**RE: 6/2019/0370/COND – Comet Hotel, St Albans Road, West Hatfield, AL10 9RH**

Thank you for consulting us on the above application for the submission of details pursuant to condition 7 (Hard and Soft Landscape Plan) 8 (Tree, Shrub or Hedge works ) 10 (Approved Landscaping Plans) 13 (Location, Design and Specification of Refuse Bin and Recycling Materials ) 17 (Urban Drainage ) and 22 (Scheme for odour control) on planning permission 6/2016/1739/MAJ, at Comet Hotel, St Albans Road, West Hatfield, AL10 9RH.

We advise the LPA that the information submitted in support of condition 17 in relation to surface water does not comply with the requirements set out in condition 17. Therefore, we recommend to the LPA not to discharge condition 17.

FW1263 400C13

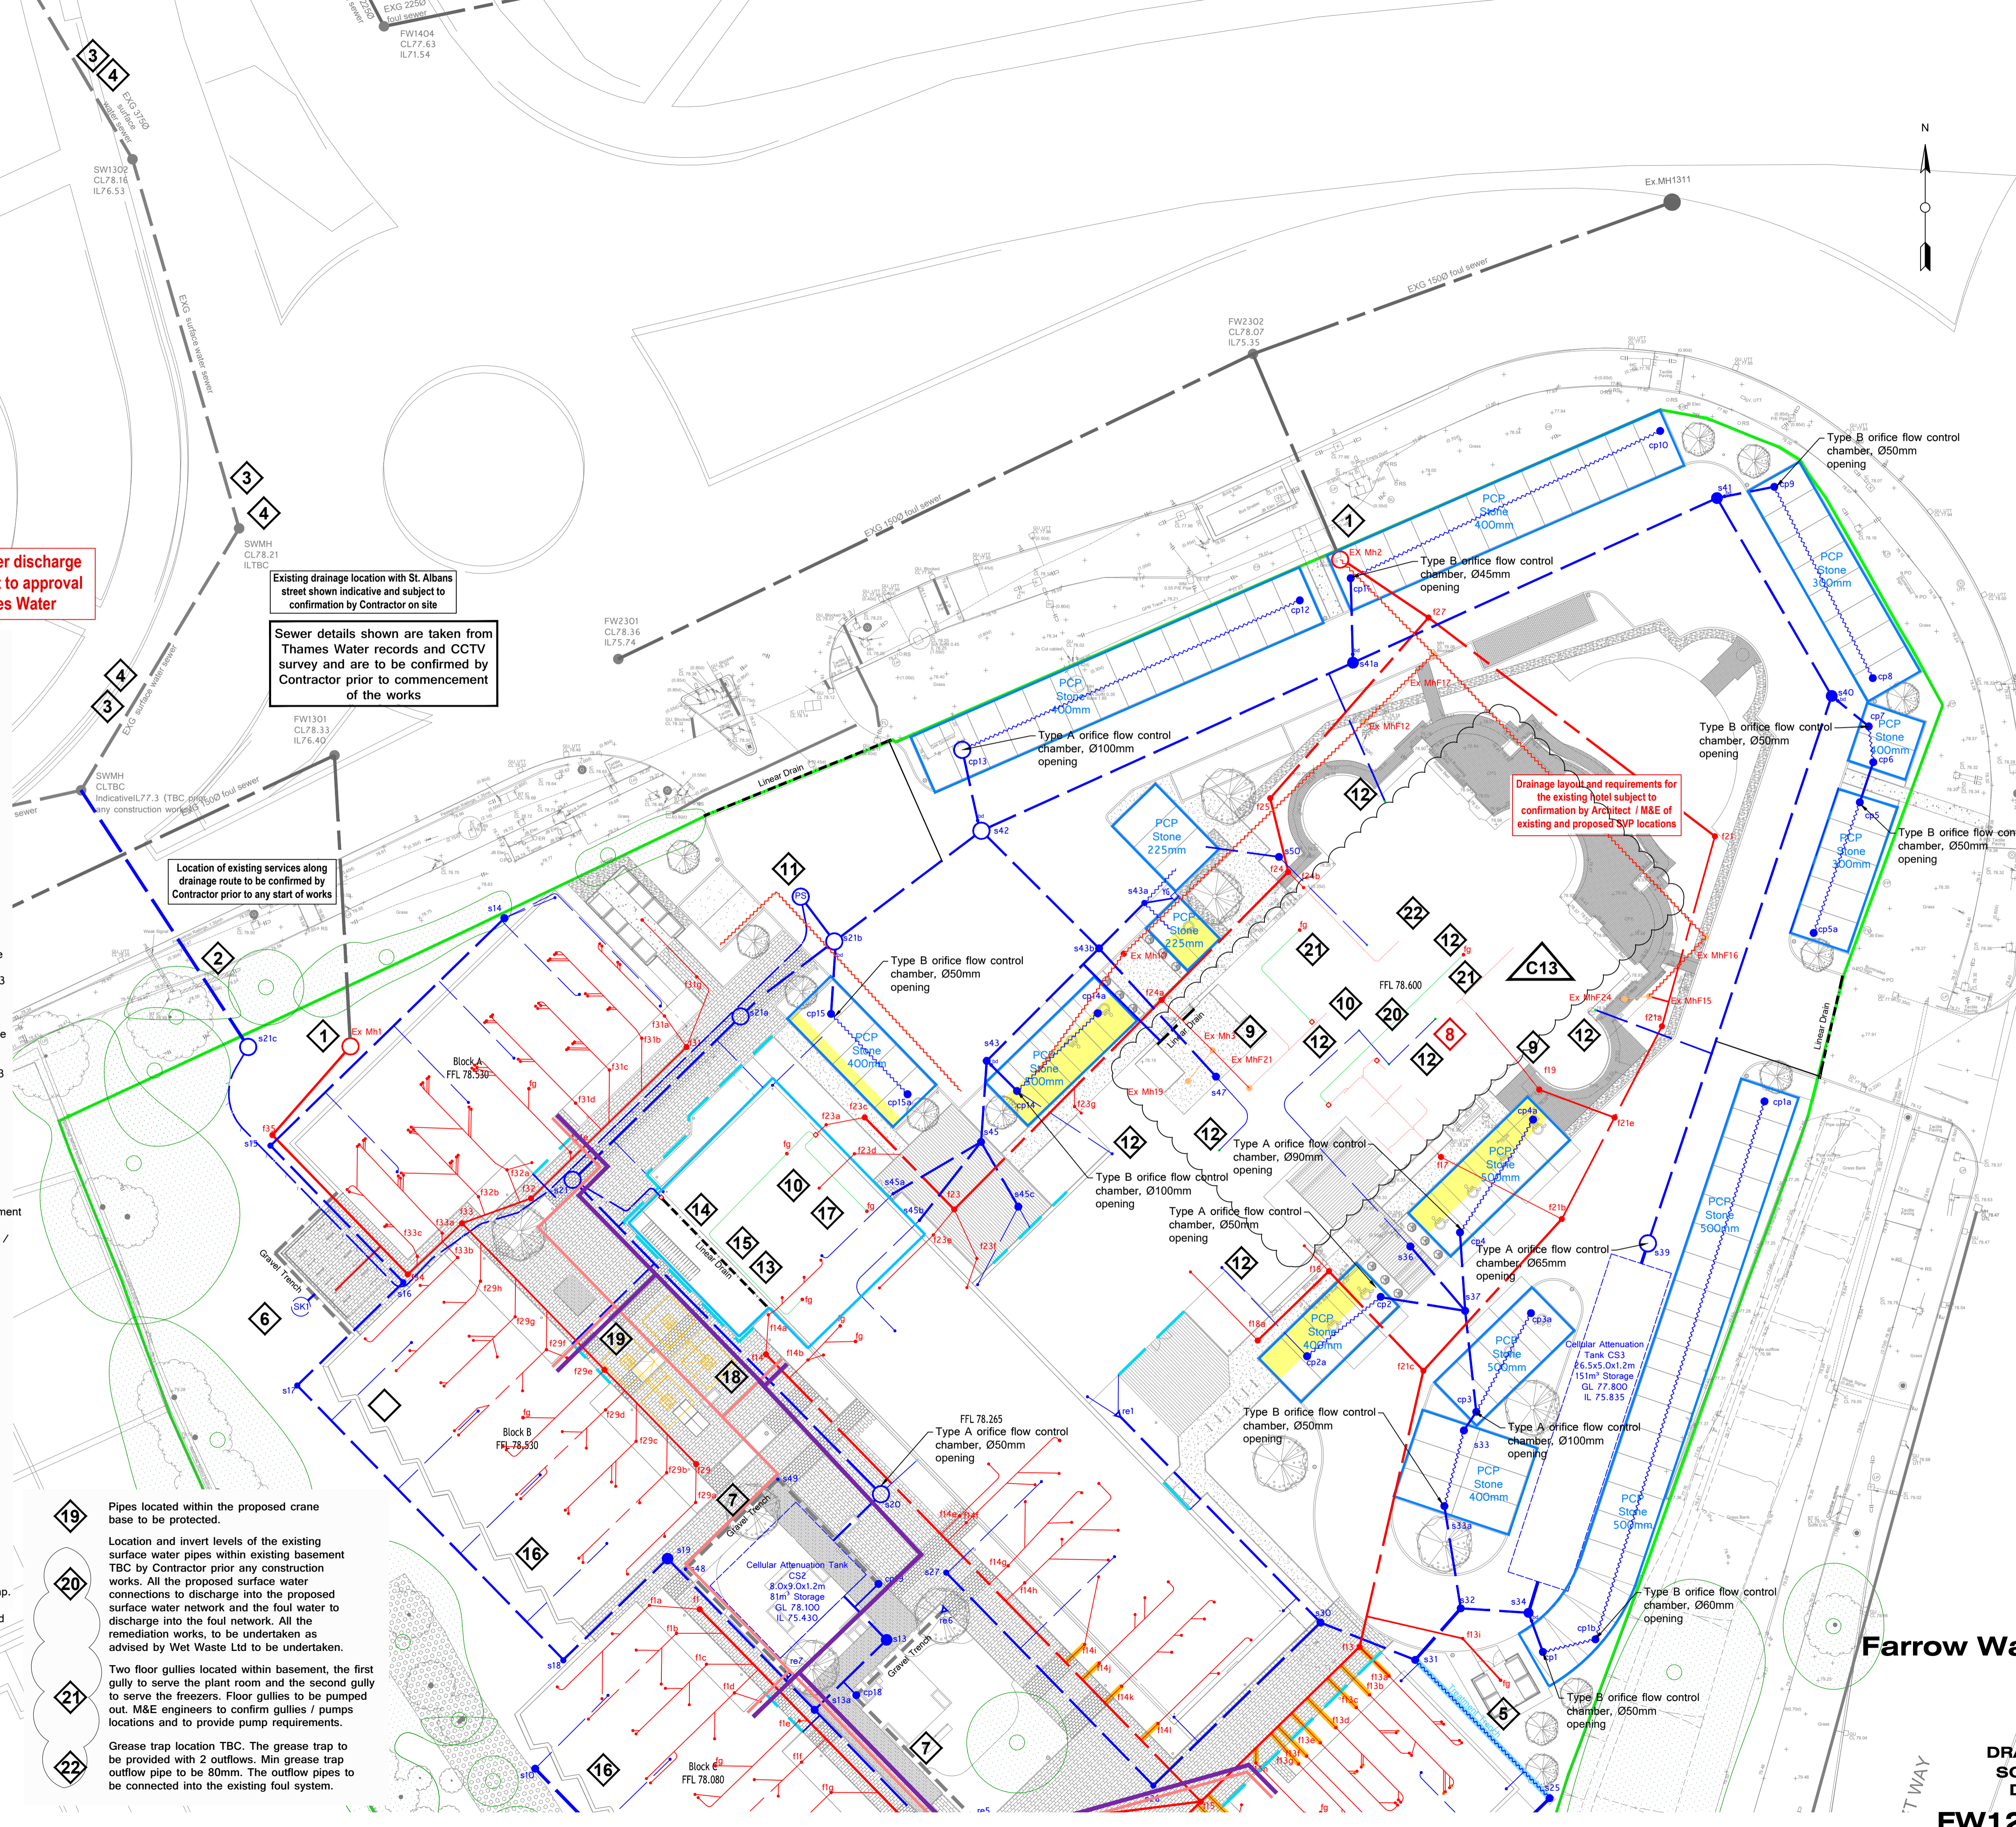
We note that the applicant has submitted an updated drainage layout. Moreover, we note that the final discharge location has been updated and does not include discharge of surface water from the site into Ellen Brook via a new off-site connection. Therefore, as the LLFA, we believe that the updated drainage strategy does not comply with condition 17.

We note that the applicant has submitted drainage schedule sheets, drainage construction details drawings and an updated modelling. We have noticed that the applicant has identified a flooding within the 1 in 100 year plus climate change allowance. Therefore, we would advise the LPA that these areas should be identified on a drainage layout with identified depths and extents.

Moreover, as stated on the drainage layout and as this is a pre-occupation condition, we believe that a CCTV survey should be undertaken and results should be submitted to the LPA.

Drainage Alignment  
Horiz. 1:200, Vert. 1:100

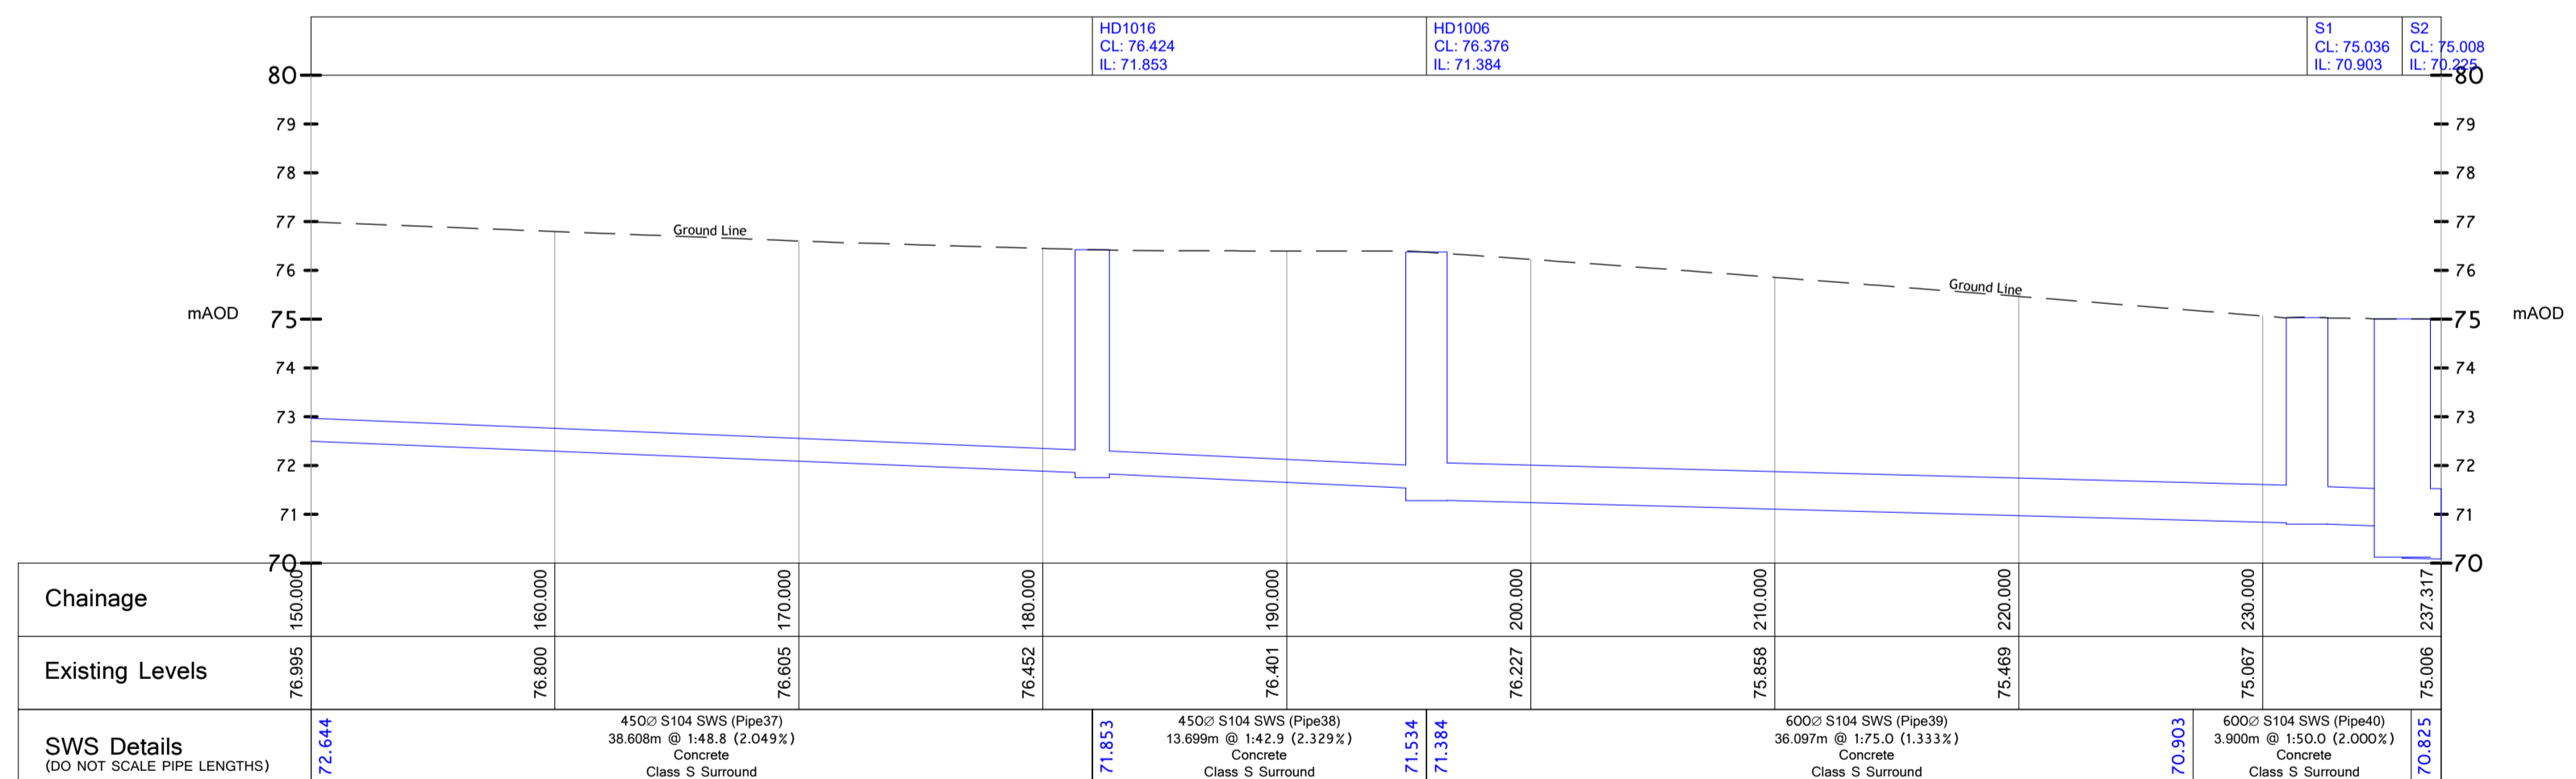
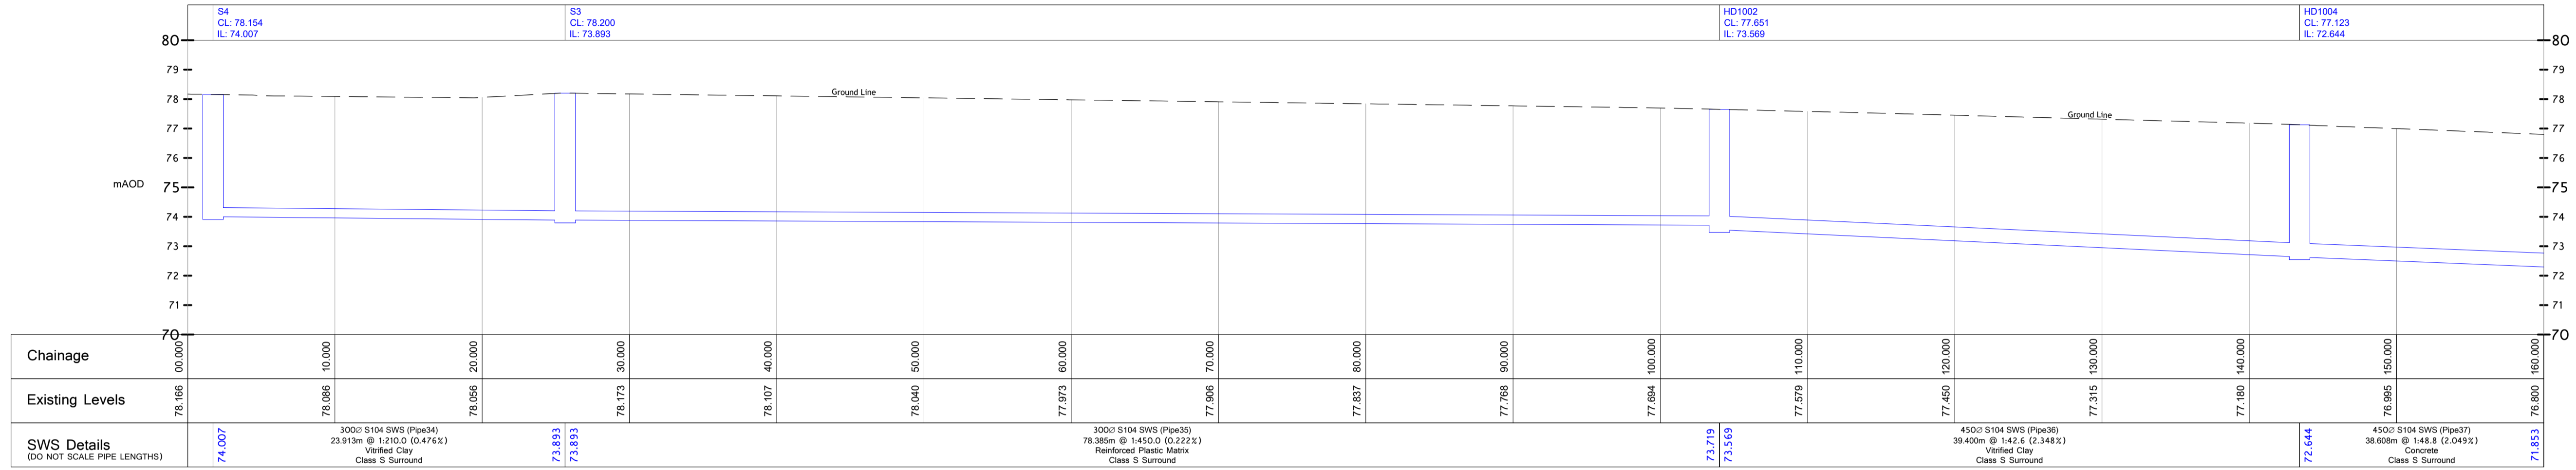
Moreover, if the applicant intends to discharge surface water from the site into the existing third party private drainage off site (which has not been yet adopted), we would strongly advise the LPA that an agreement should be provided from third party landowner that they agree with the proposed connection location and the proposed discharge rate.

We would like to highlight to the LPA that the applicant has changed the final surface water drainage discharge location. Therefore, as the LLFA, we believe that the updated drainage scheme does not comply with condition 17. We would advise that the applicant should clarify this with the LPA.
